Environmental Health Consultation Response

To	Mr S Davis
Date	17-08-2026
Planning Ref	F/36/26/OUT
Site Description	Paynters Croft Burndell Road Yapton Arundel West Sussex BN18 0HR
Date of Application	2026-07-08 00:00:00
Category	Outline Planning Permission
Recommendation	No Objection No Objection – with conditions Objection Holding Objection

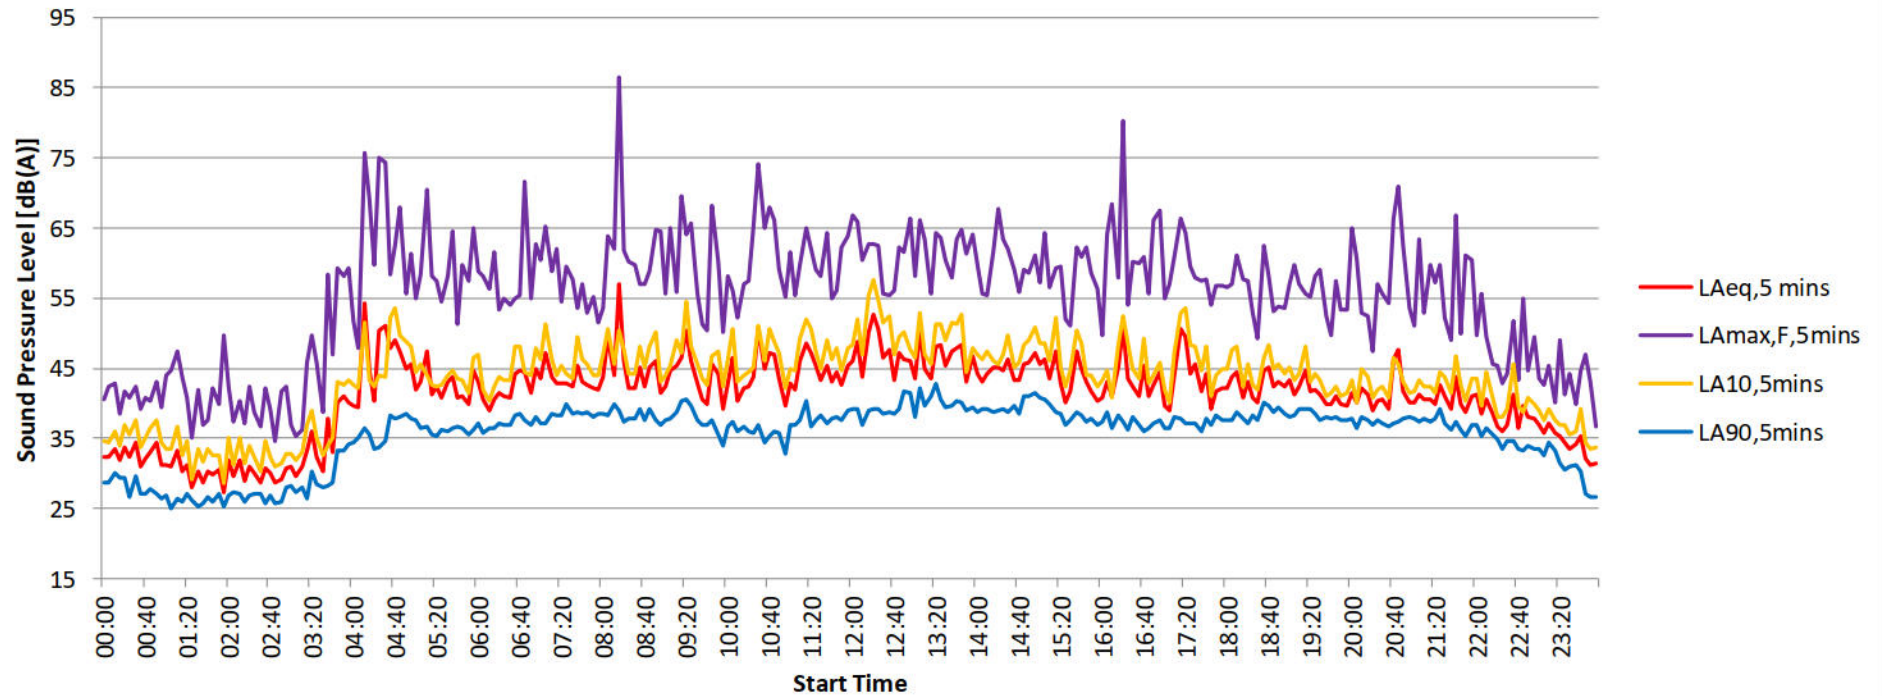
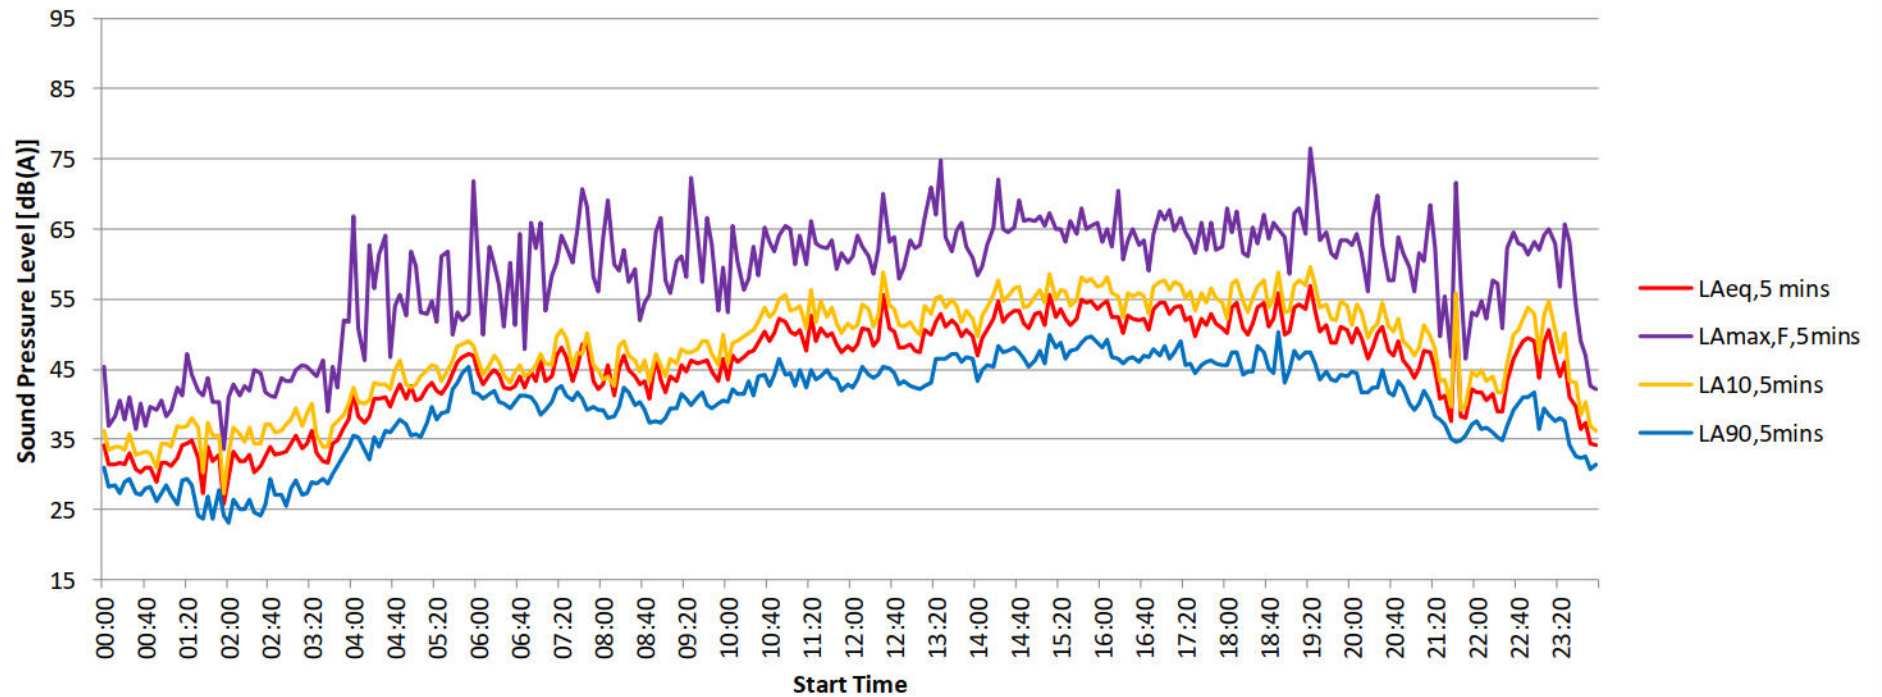
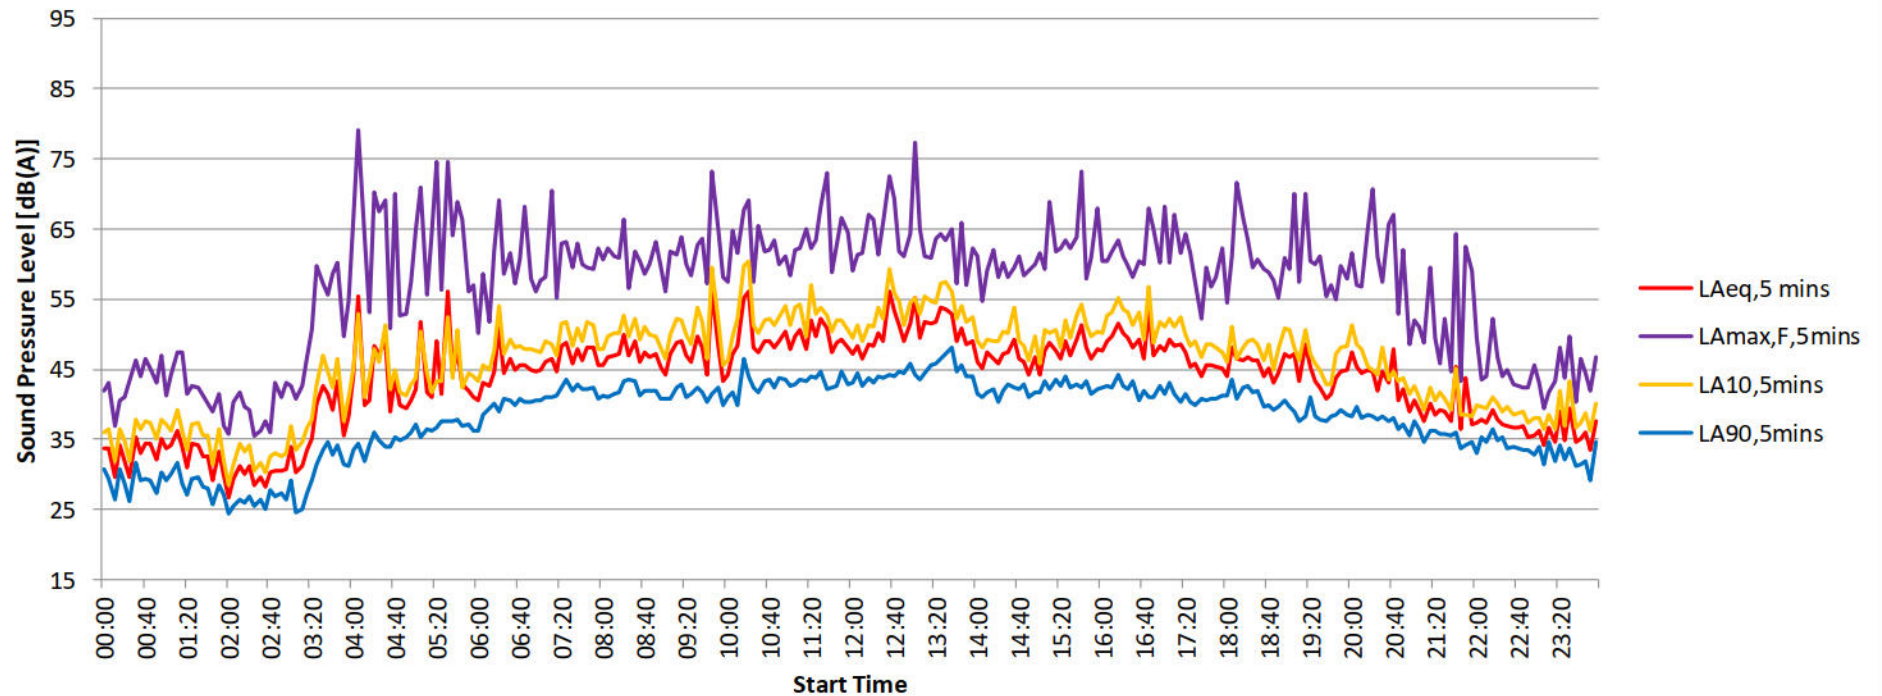
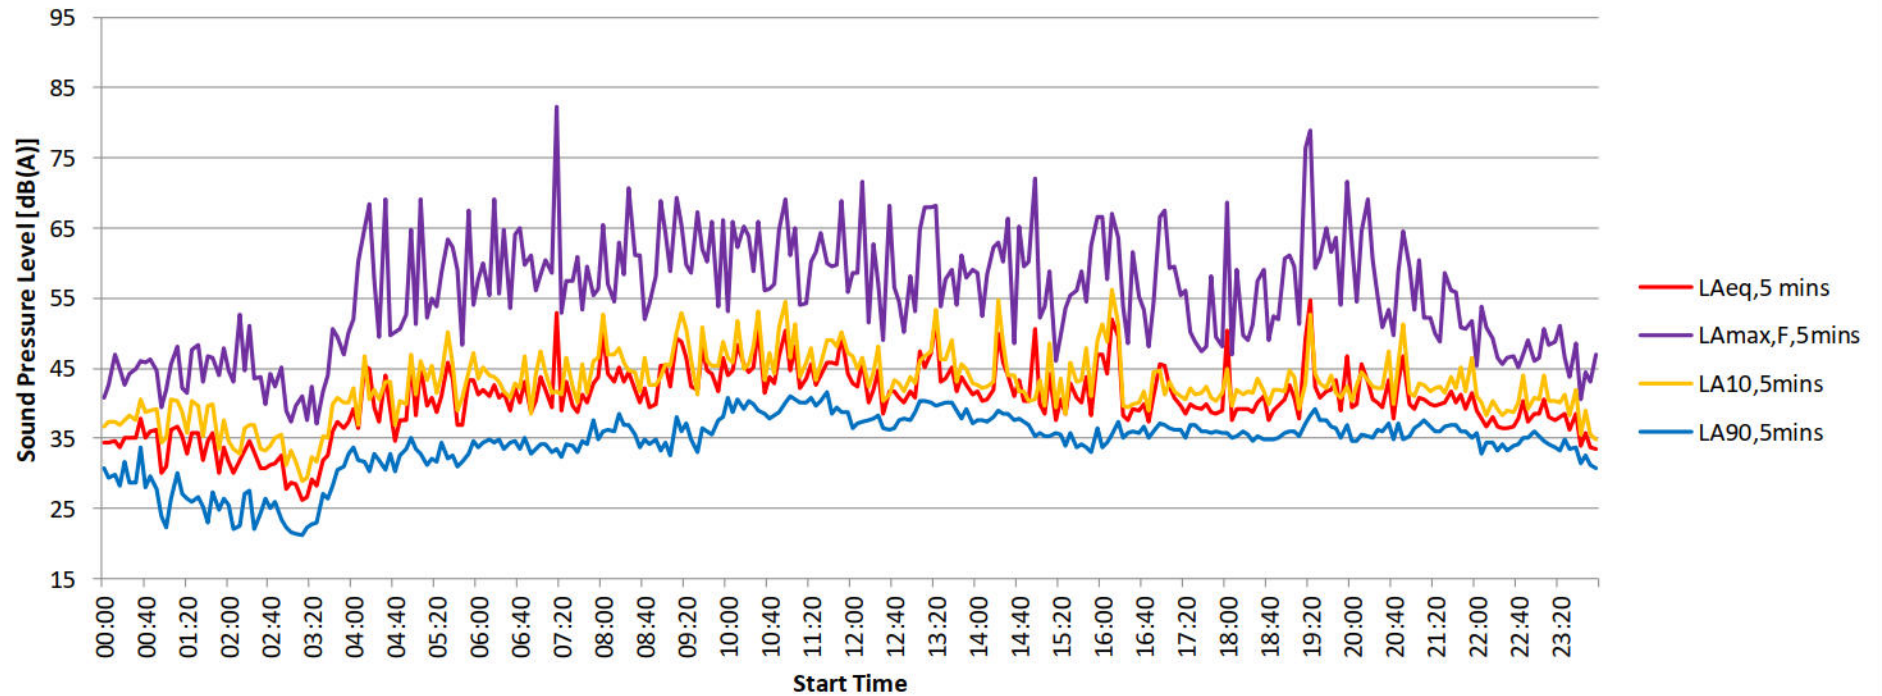
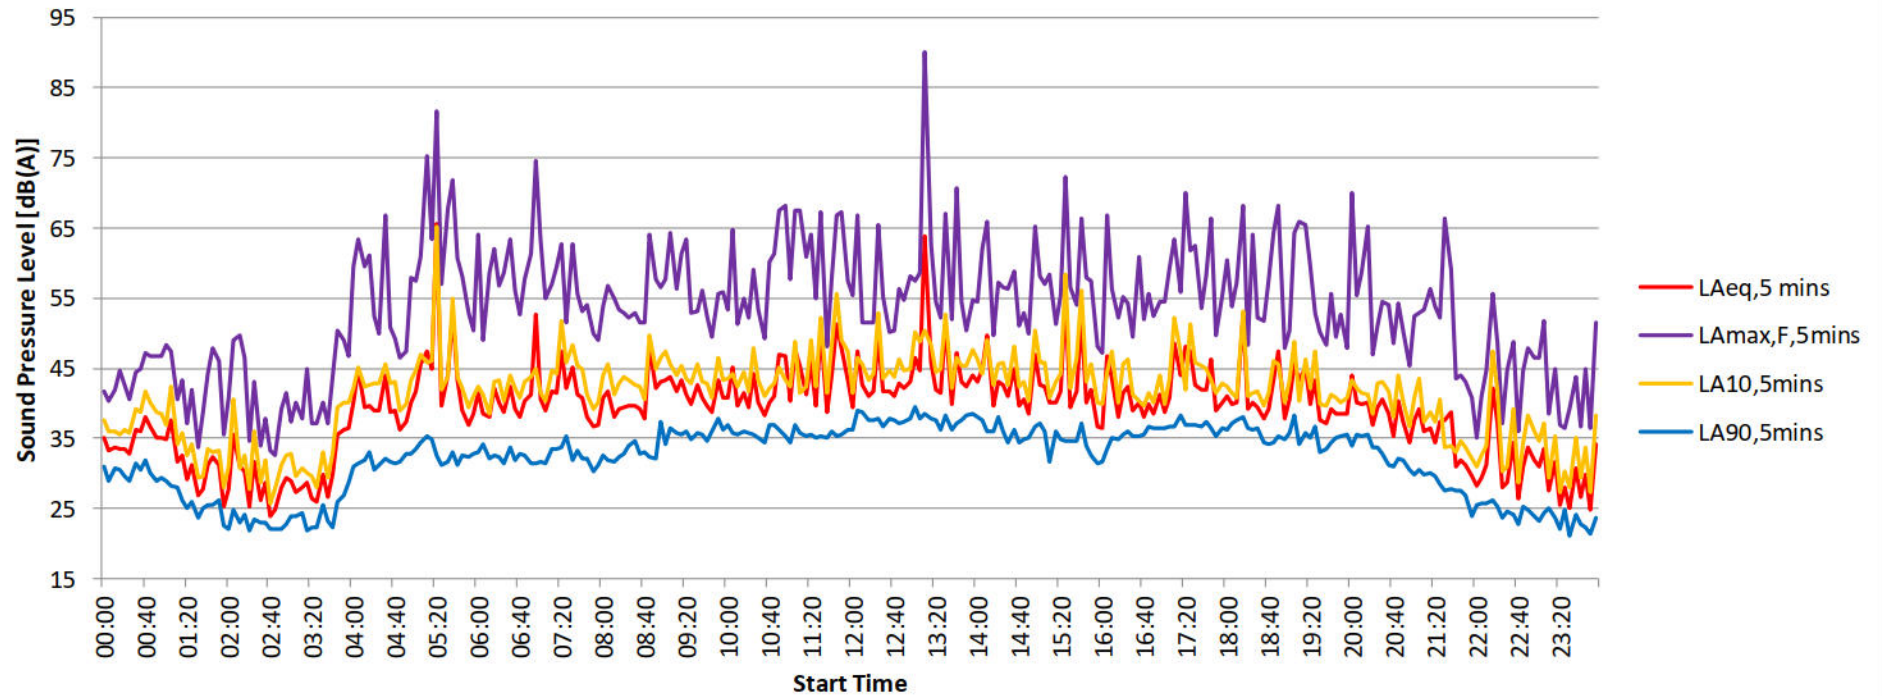
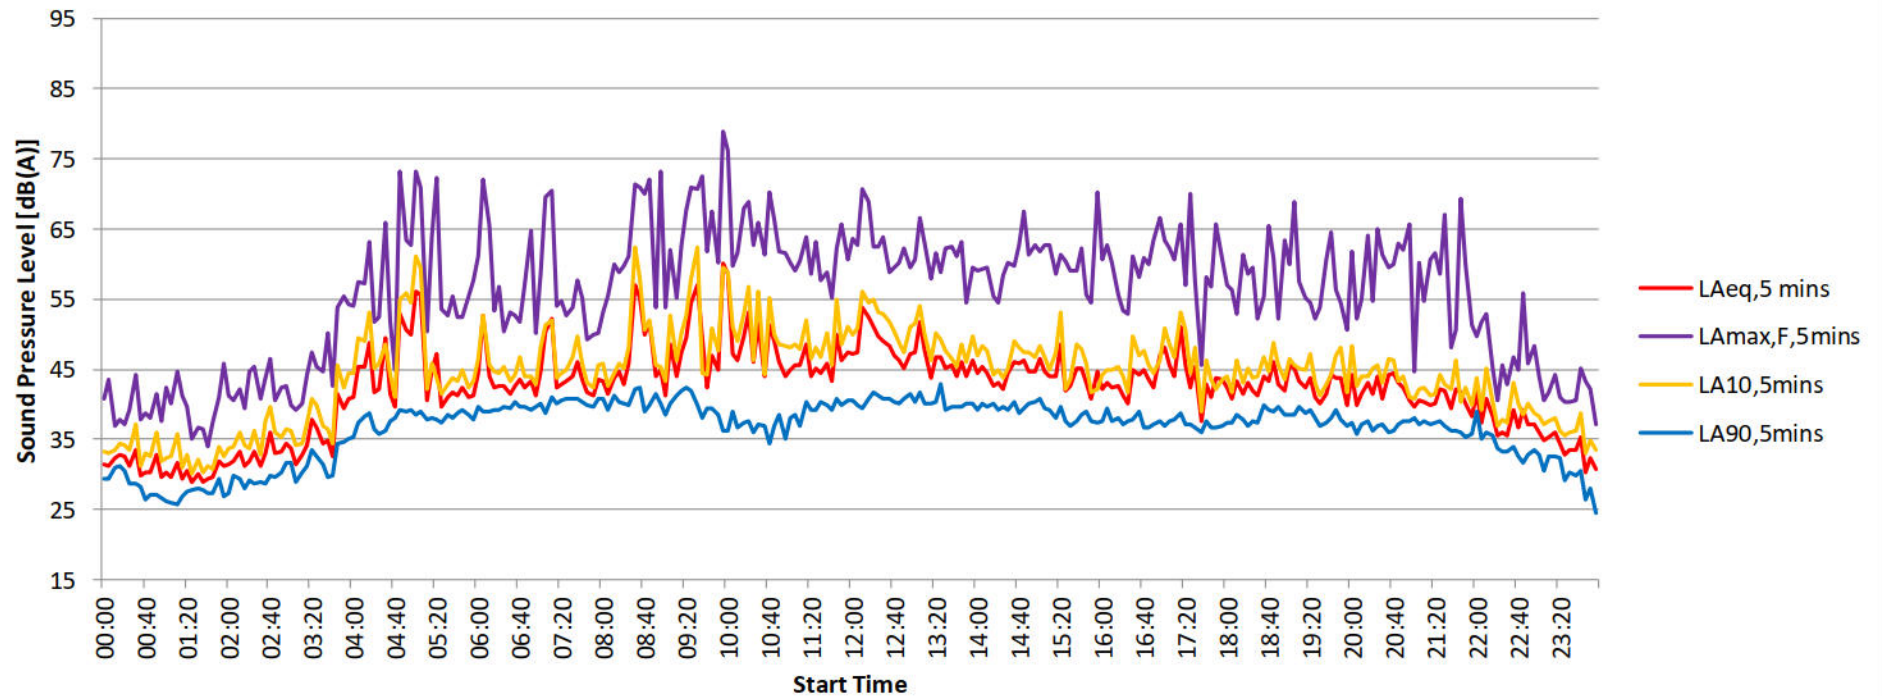
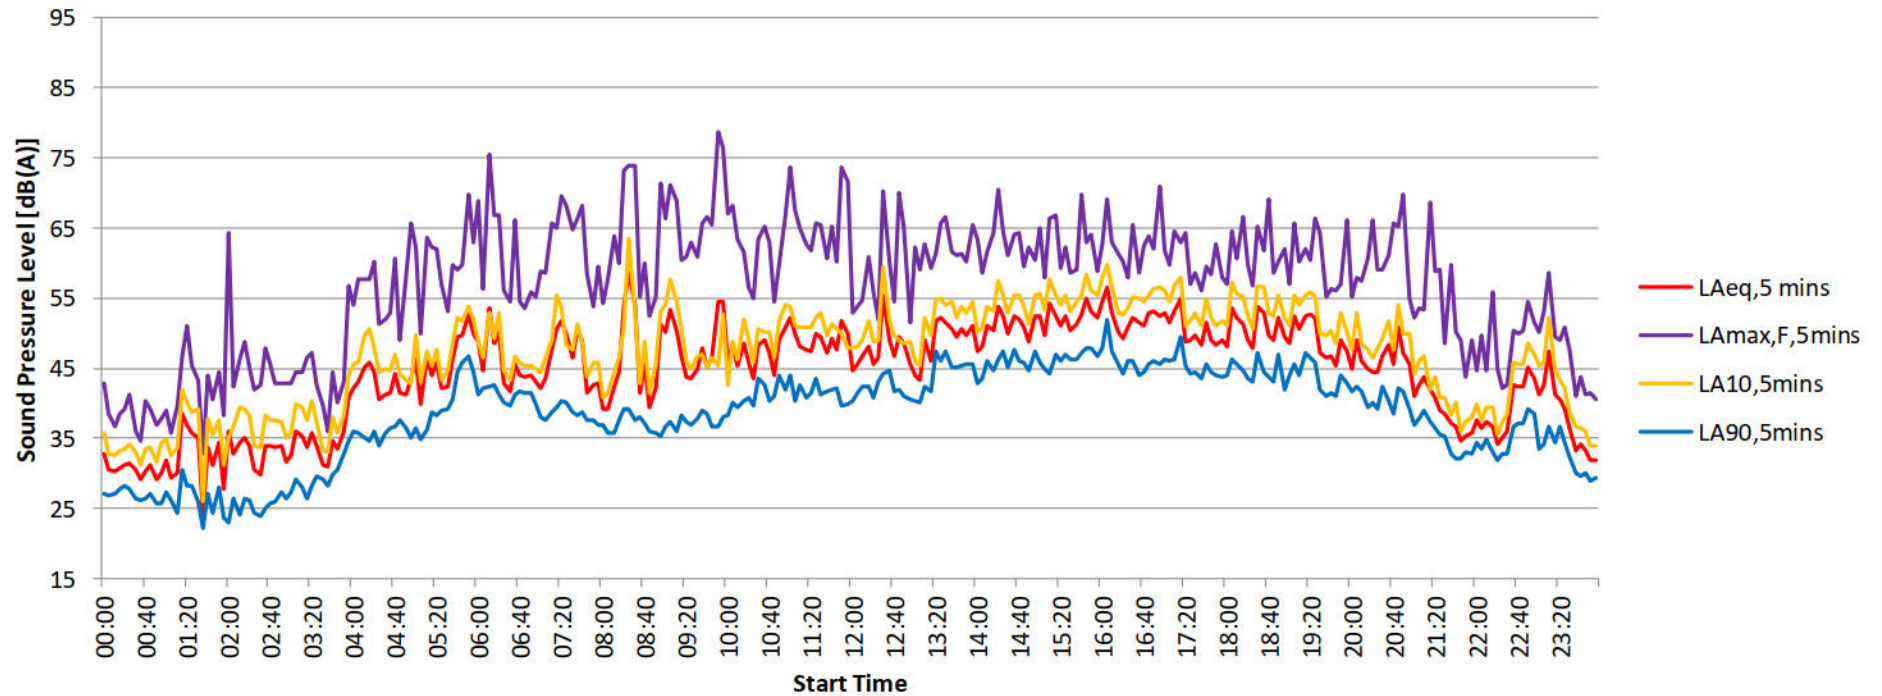
A noise assessment has been submitted, prepared by Phlorum, reference 13174, dated May 2026. The report is generally sound in approach; however, the noise survey work on which it relies was undertaken in 2024. Since that time, I understand that the adjoining industrial units have increased their hours of operation, this change may affect the noise climate to which future residents would be exposed.

On this basis, further confirmation is required to demonstrate that the noise levels and internal and external amenity standards set out in the Phlorum report remain representative and achievable having regard to the current and permitted operation of the adjoining industrial and waste uses.
